PLANNING APPLICATION CONSULTATION RESPONSE

Application Number:	3/2021/1134
Proposal:	Development of Phases 2 and 3 for the erection of 198 dwellings, including affordable housing and housing for older people, with associated landscaping, SUDS, LEAP, and areas of open space.
Location:	Land East of Chipping Lane, Longridge, Ribble Valley

Lead Local Flood Authority Position

Figure 6: Preliminary Proposed Drainage Plan extract (Betts Hydro, 2021)

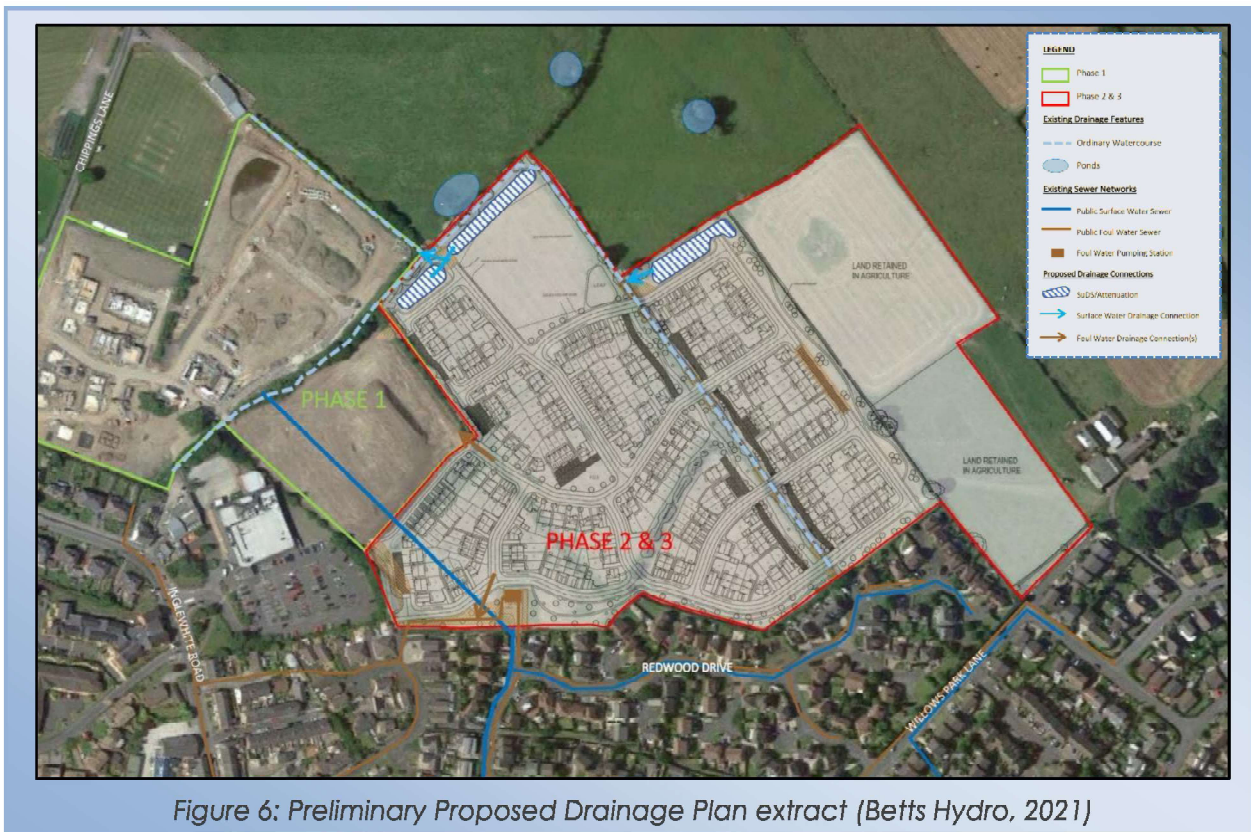
The submitted drainage layout plan indicates that the applicant intends to construct within 8 metres of the open watercourse. Construction within 8 metres of an open watercourse is not advised as access for maintenance purposes is restricted and it has the potential to pose an undue flood risk to structures should fluvial flooding occur.

It is therefore advised that the applicant modifies the proposed drainage layout plan to ensure that no structures are constructed within 8 metres of the top of the banks of the watercourse.
